REFUSAL OF PLANNING PERMISSION

APPLICATION NO. 2016/1478

Proposal Formation of vehicular access.

At 18 Roper Lane, Thurgoland, Barnsley, S35 7AA

Plan No: SH6027

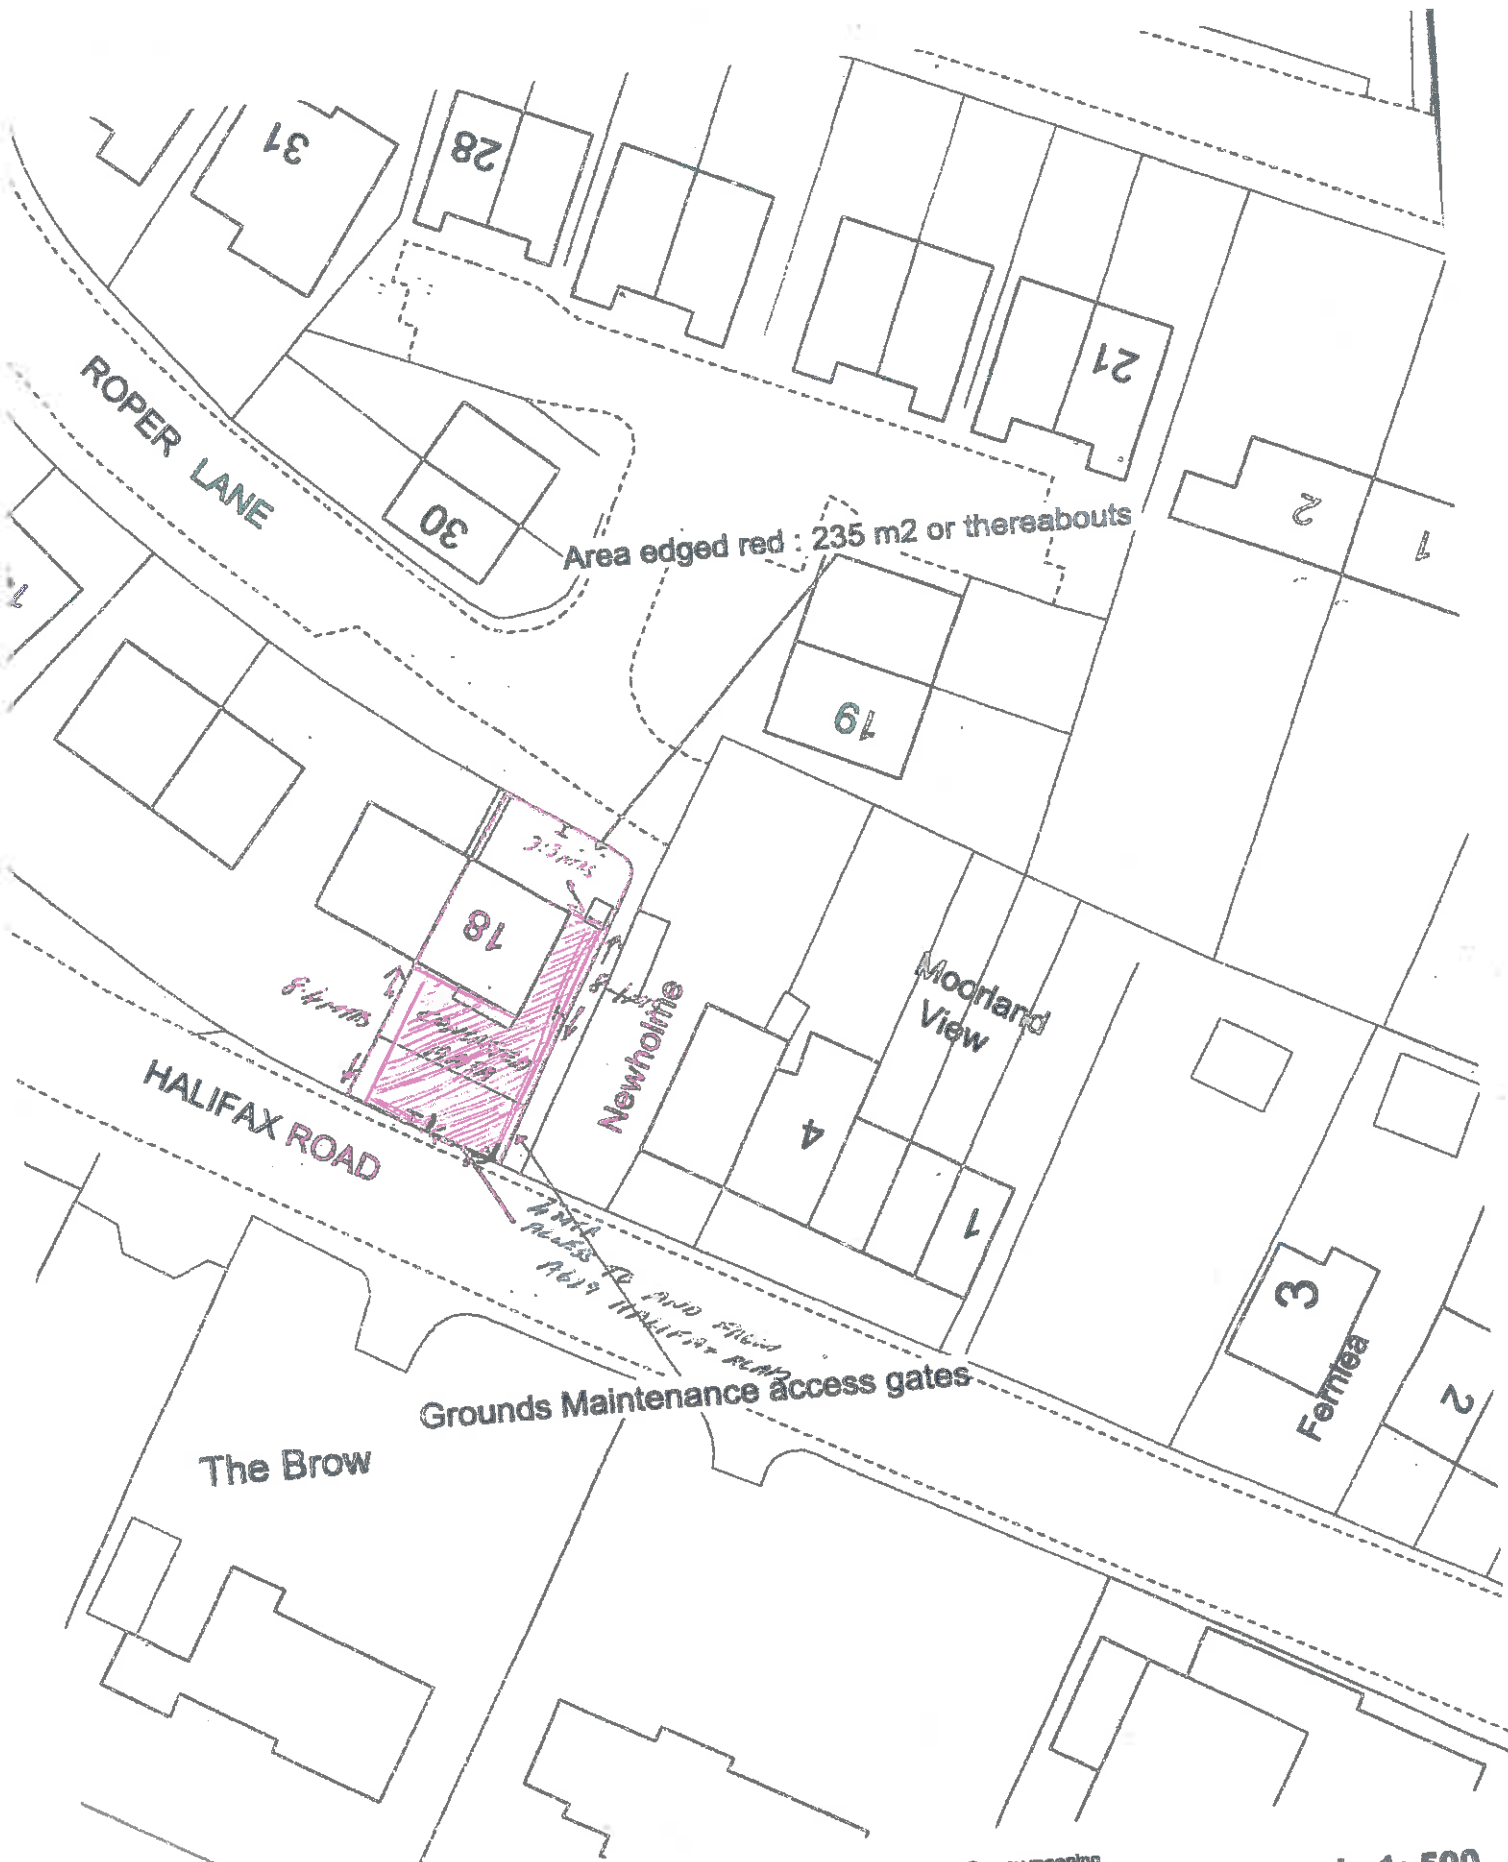
- 1 The proposal would result in the unnecessary proliferation and intensification of individual accesses onto a classified road which would be detrimental to road safety and the free flow of traffic contrary to Core Strategy Policy CSP26: New Development and Highway Improvement.
- 2 The proposed development would give rise to conditions prejudicial to highway safety due to the lack of provision of pedestrian intervisibility splays contrary to Core Strategy Policy CSP26: New Development and Highway Improvement.
